Please ask for: Nicola Moore
Email: nicola.moore@arun.gov.uk
Telephone: Ext 37944
Our Ref: BE/115/21/HH
Your Ref:
Date: 13th July 2021

Application for Planning Permission for Works or Extension to a Dwelling

Development: Loft conversion to form new 2nd floor with roof alterations to form gable end.
Location: 19 South Way Bersted PO21 5HB

sheet 2 a of 3

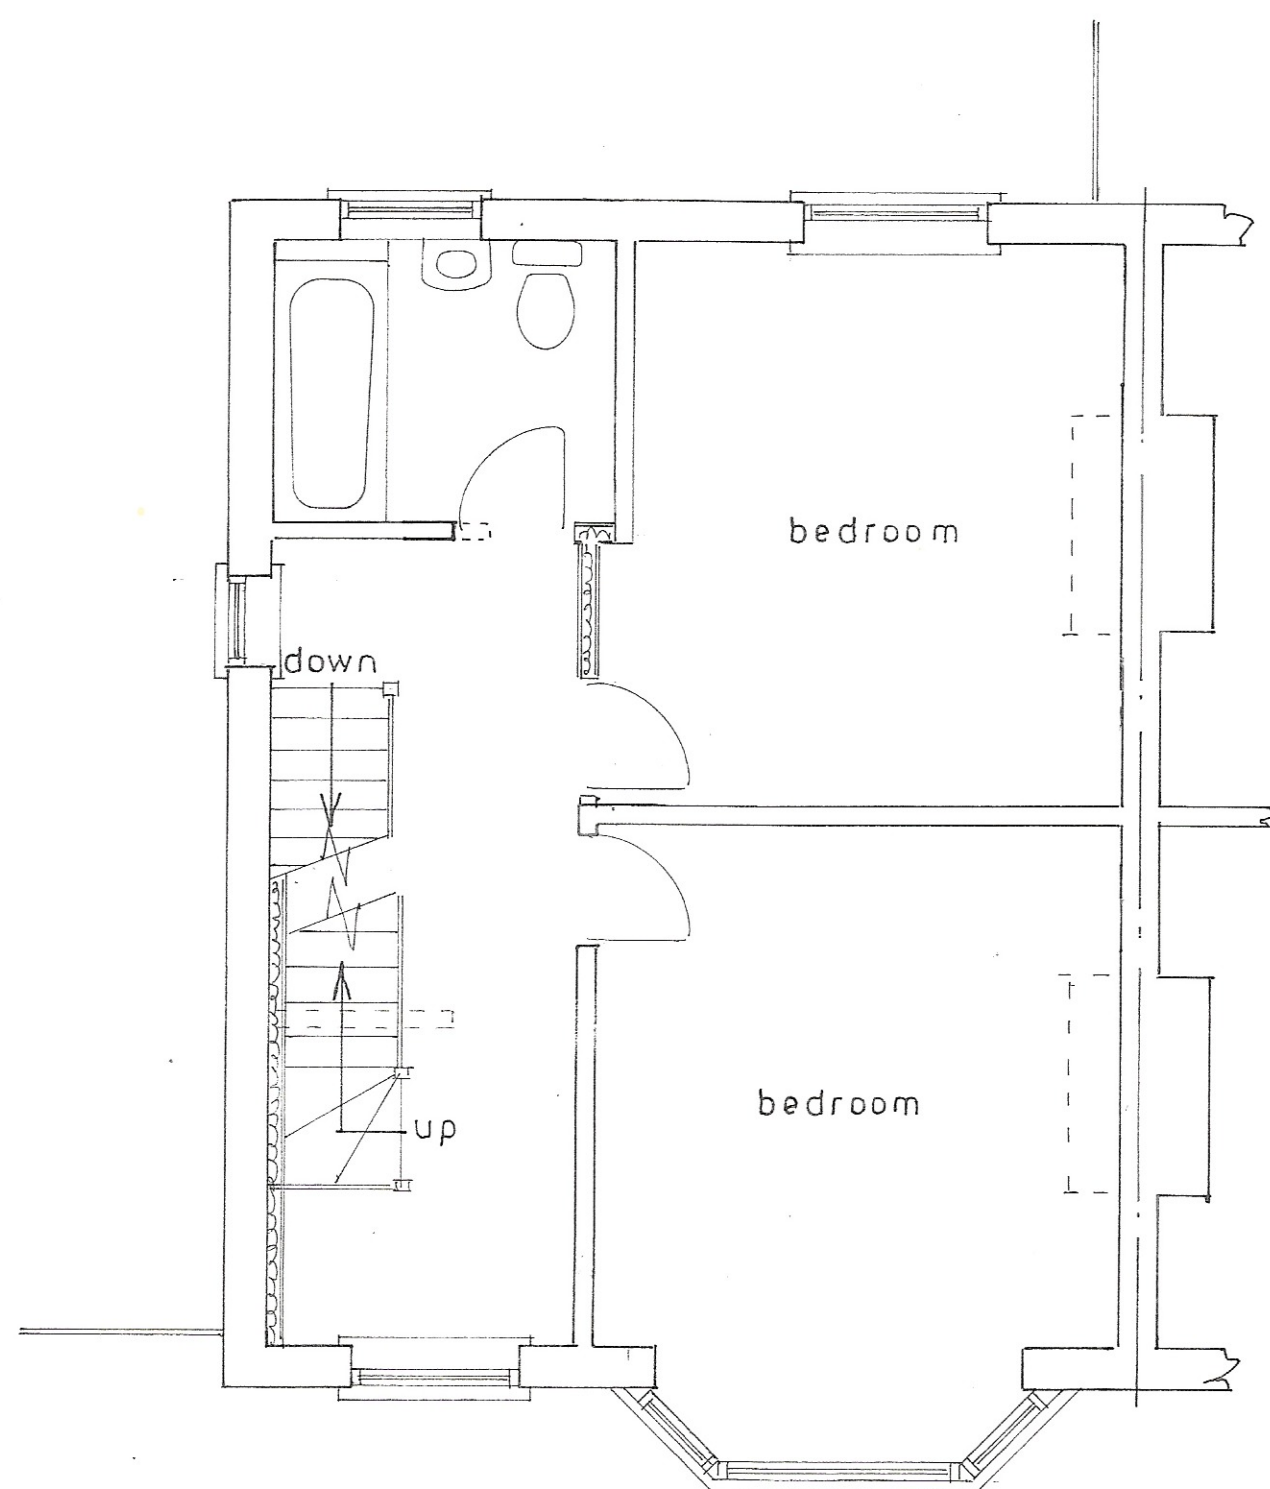
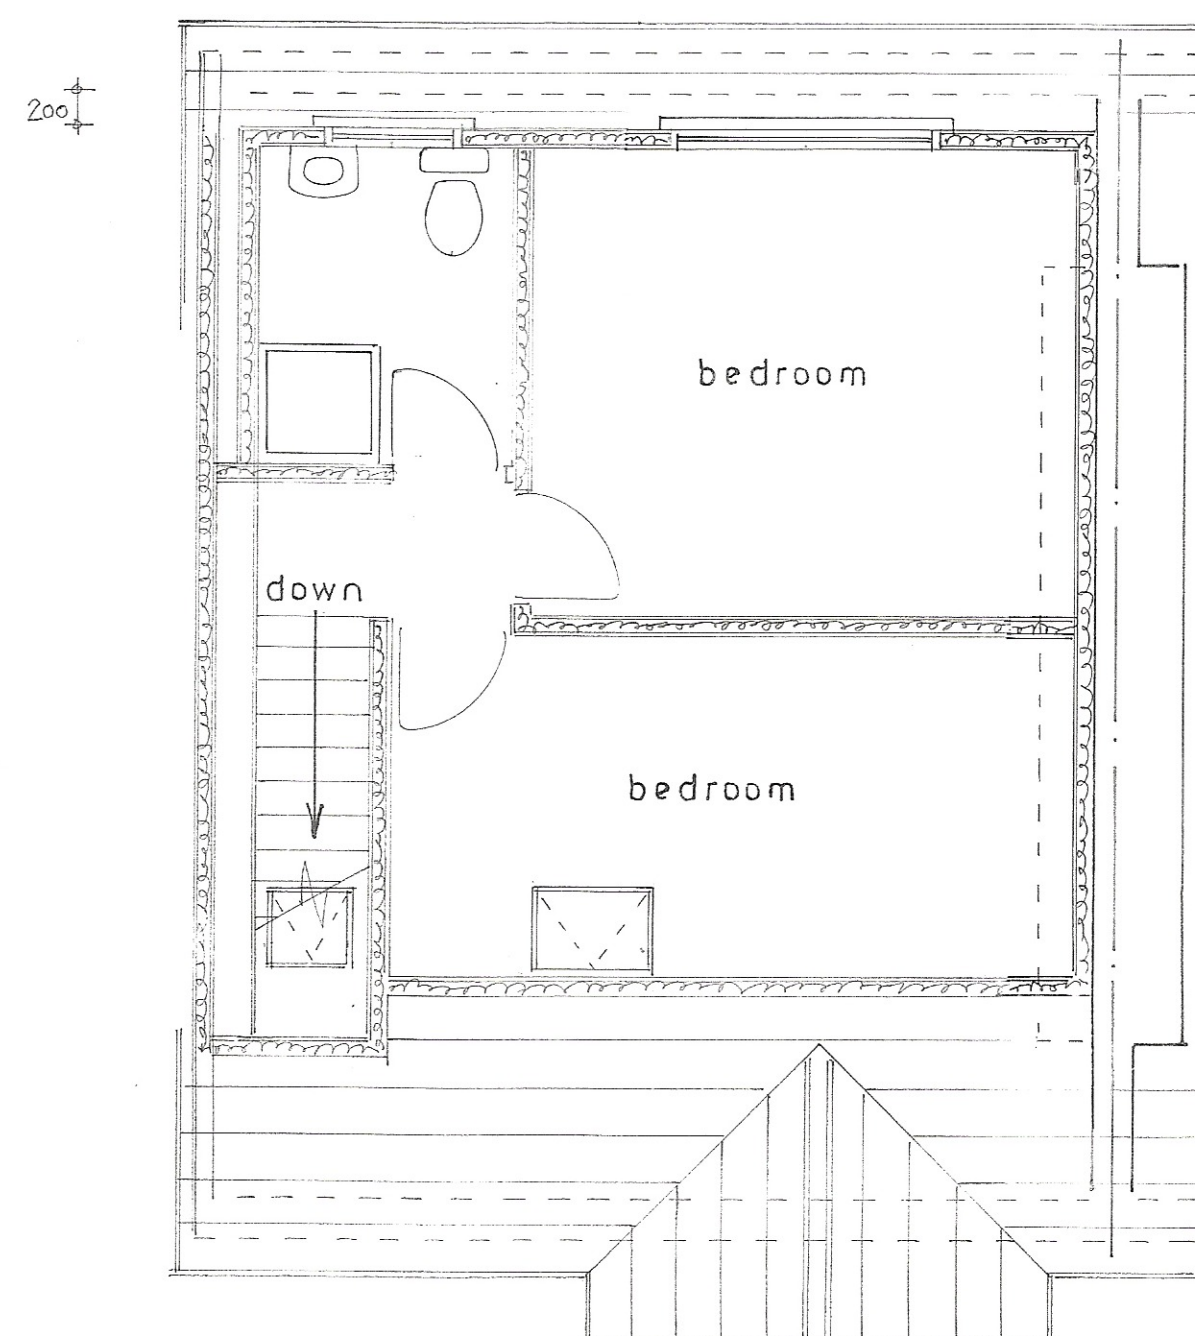
The 2nd floor windows on the Proposed East Elevations measure 1.6m and 1.1m, however on the Proposed 2nd Floor plan they are 1.6m and 0.8m. Please amend accordingly and re submit.
